# CITY OF ALBUQUERQUE

Planning Department

**Re: Citizen Church North  
7518 Oakland Ave NE  
Request for Certificate of Occupancy- 30 Day Temp  
Transportation Development Final Inspection**  
Architects Stamp Date 10-24-22 (C19D005)  
Certification dated 2-27-24

SHEET NUMBER  
AS-1.0

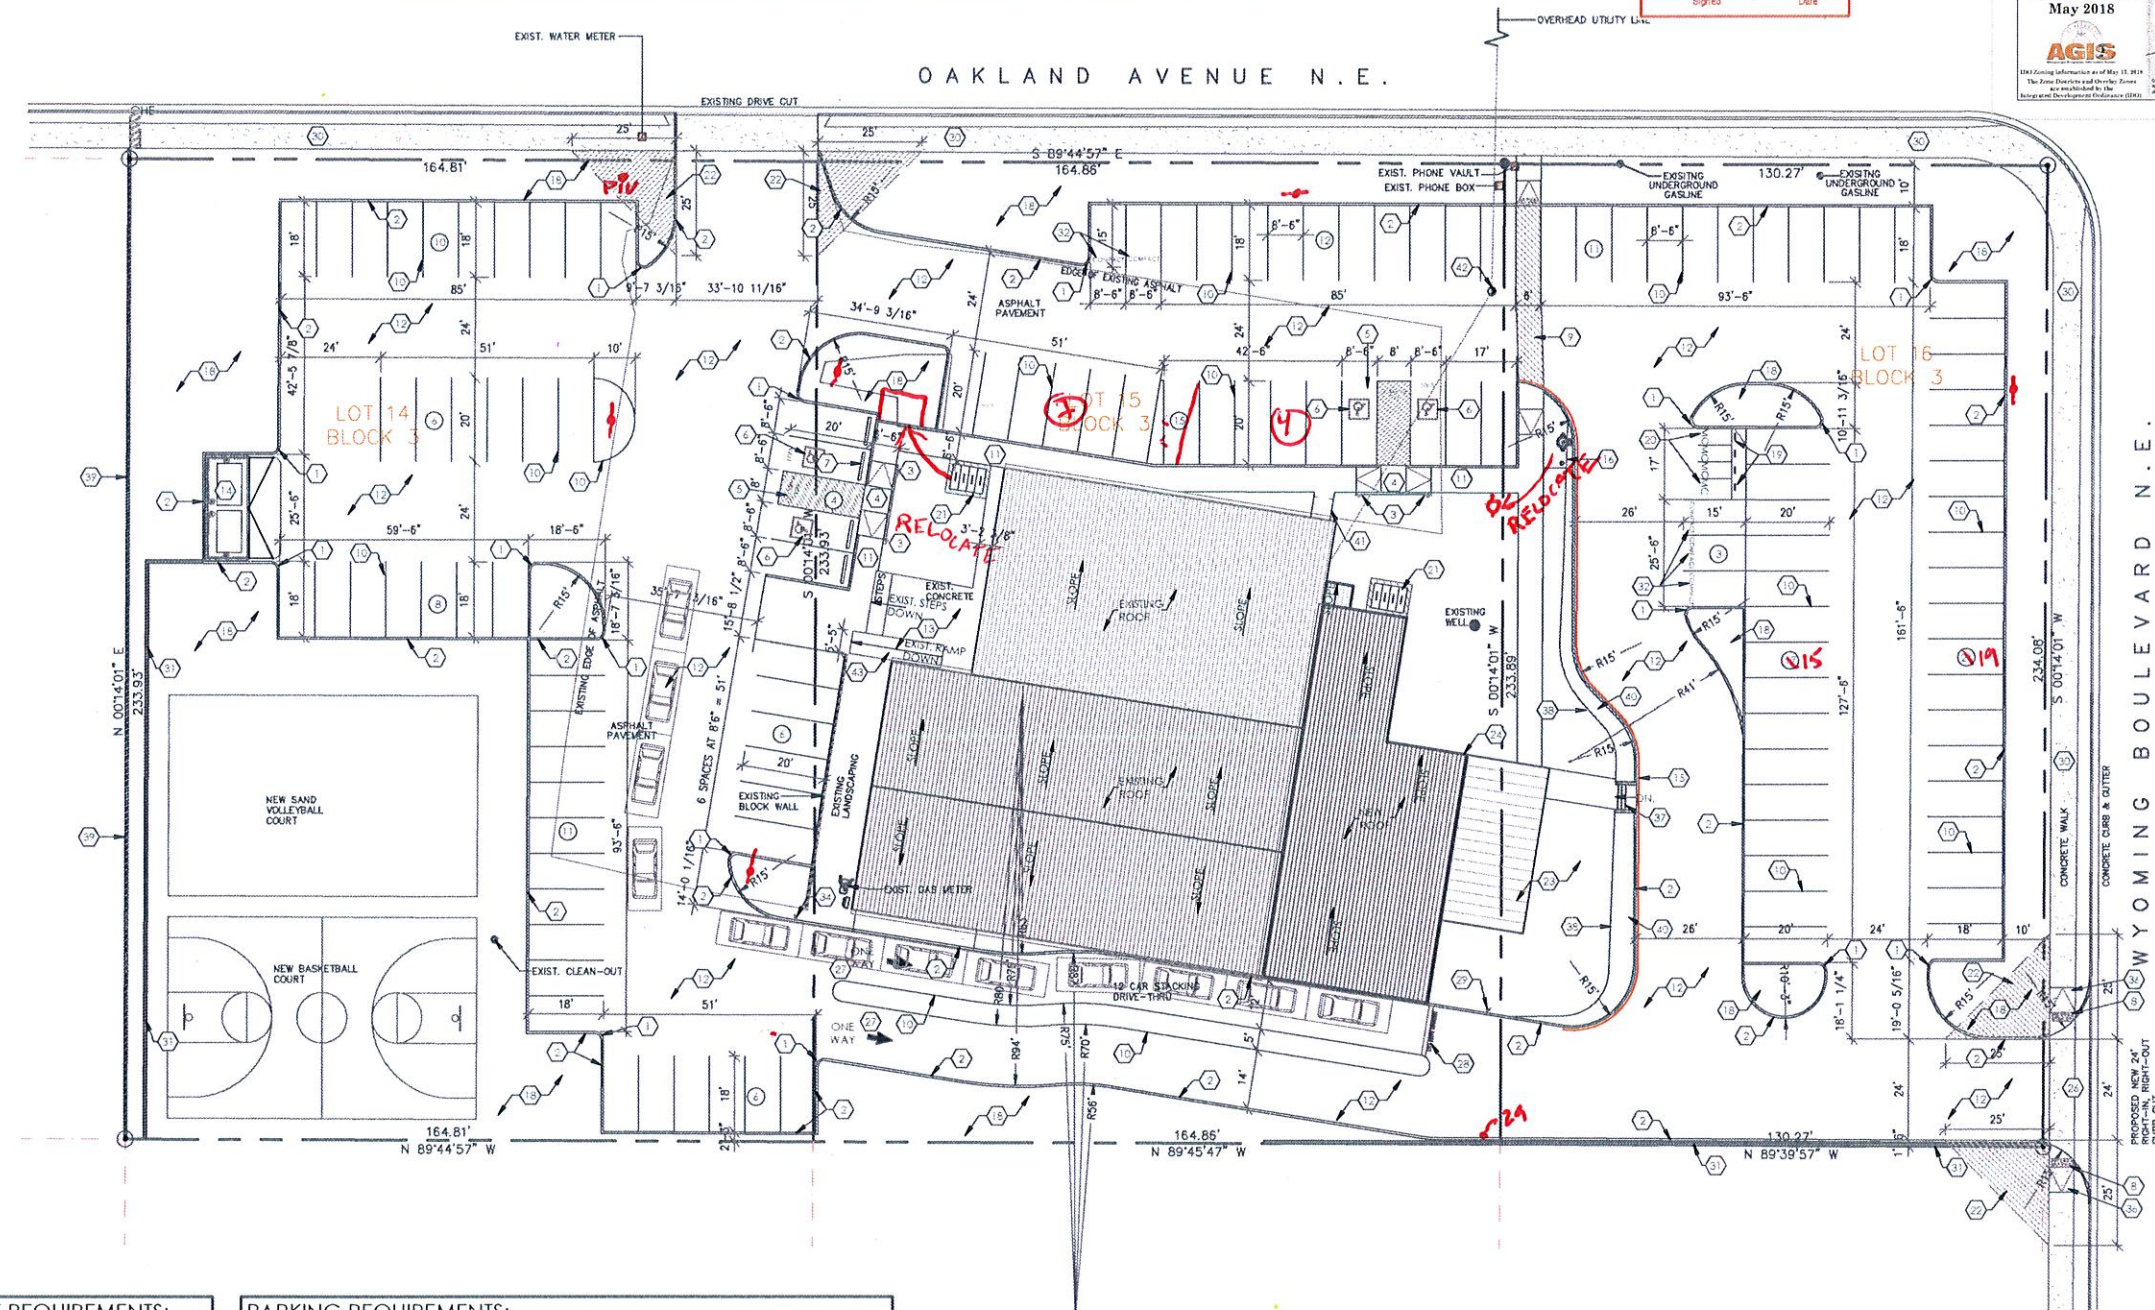
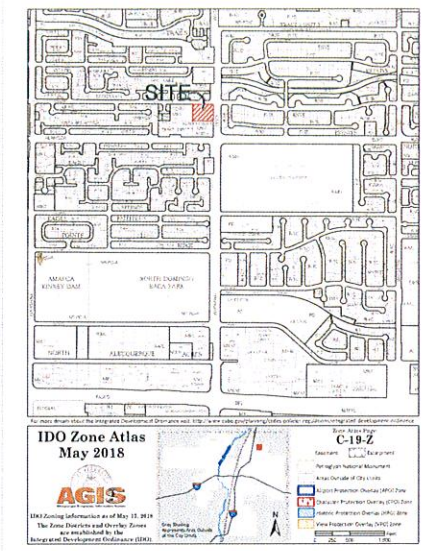
1. The bike racks were not installed.
2. The pedestrian connection to the Oakland Ave ROW was not complete.
3. The sidewalk culvert plate was not installed near the north side of the building.
4. There was material stored in the parking lot.
5. The mailbox west of the Oakland Ave entrance was too close to the sidewalk.
6. The landscaping was not complete so the public sidewalk could not be inspected.

Prior to issuance of a Permanent Certificate of Occupancy, the following items are to be addressed:
